**Macquarie University Arts Precinct, 192 Balaclava Road, Macquarie Park (SSD 8388)
Notice of Exhibition**

TAB A – Further Comments on the Preliminary Construction Traffic Management Plan

**Figure 13: Truck unloading area and swept paths – W4 carpark (Source: Applicant's EIS)**

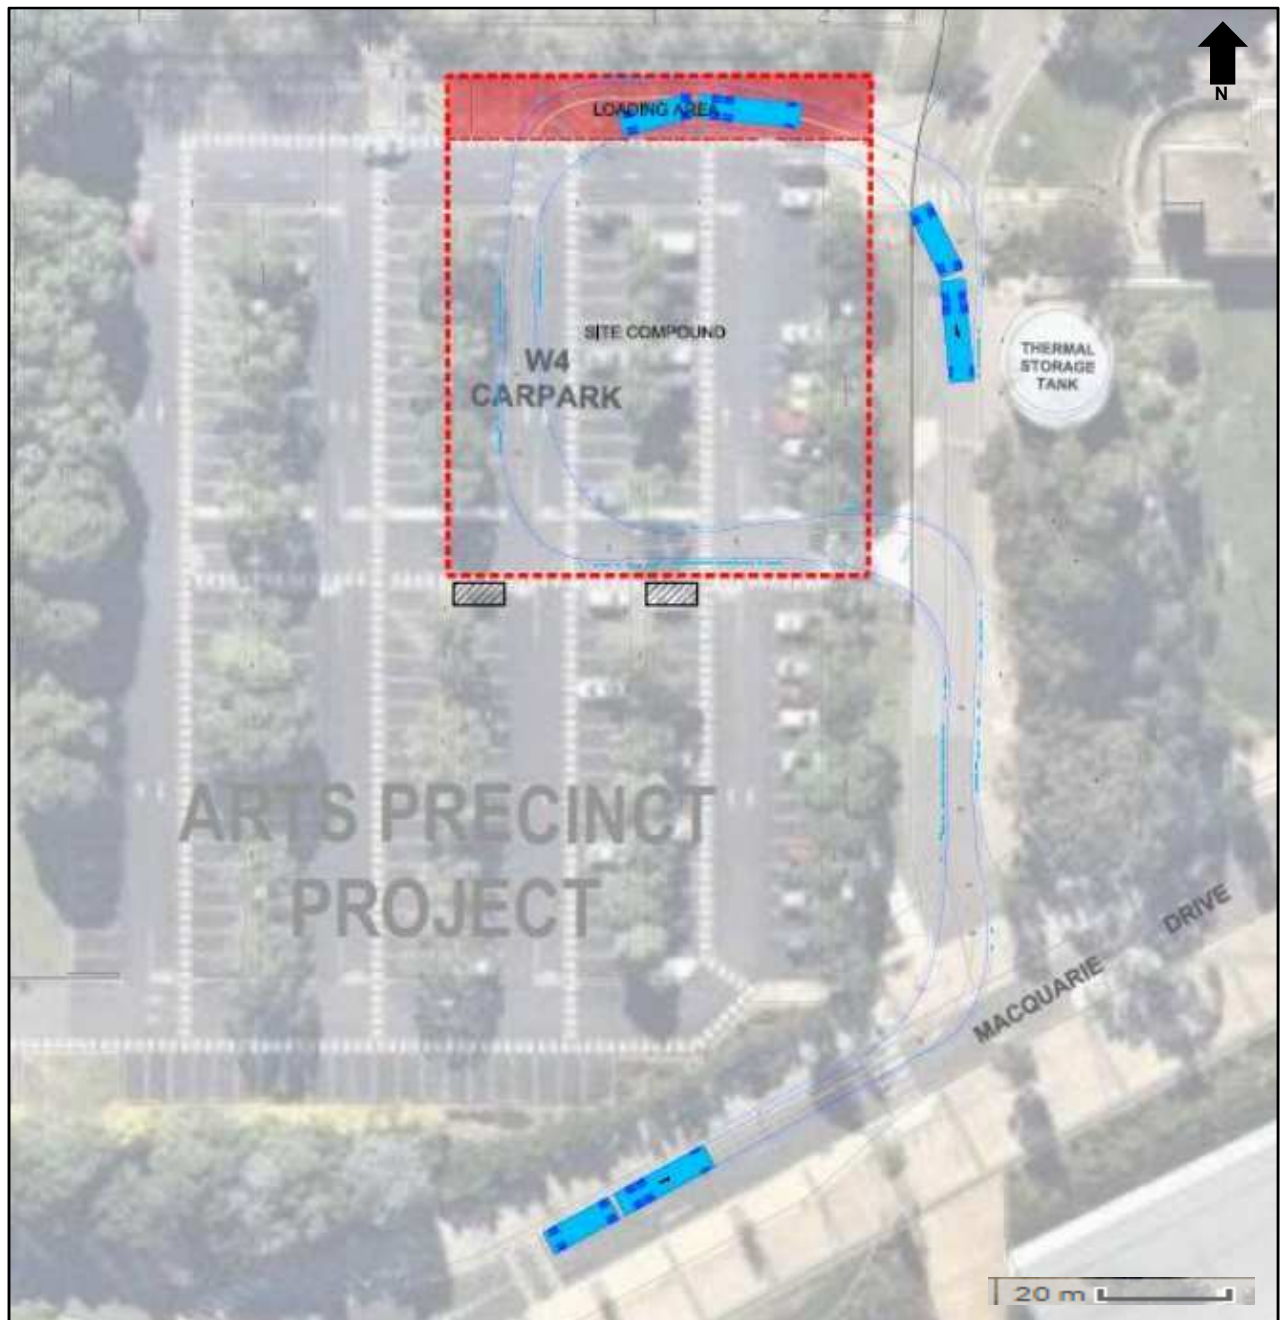
- bus routes on Epping Road, Balaclava Road and Herring Road, particularly during the operation of the TTP;
 - the removal the bus layover on the northern kerb of Hadenfeld Ave to accommodate truck and dog movements as shown in the swept path analysis at Appendix 3 – Figure 4;

- desktop study of road dimensions, traffic facilities and site constraints;
 - swept path analysis of the construction vehicles used, noting that the PCTMP stipulates that a truck and dog vehicle will only be used during excavation (2months) and a single unit truck or HRV will be used for all other construction activity.
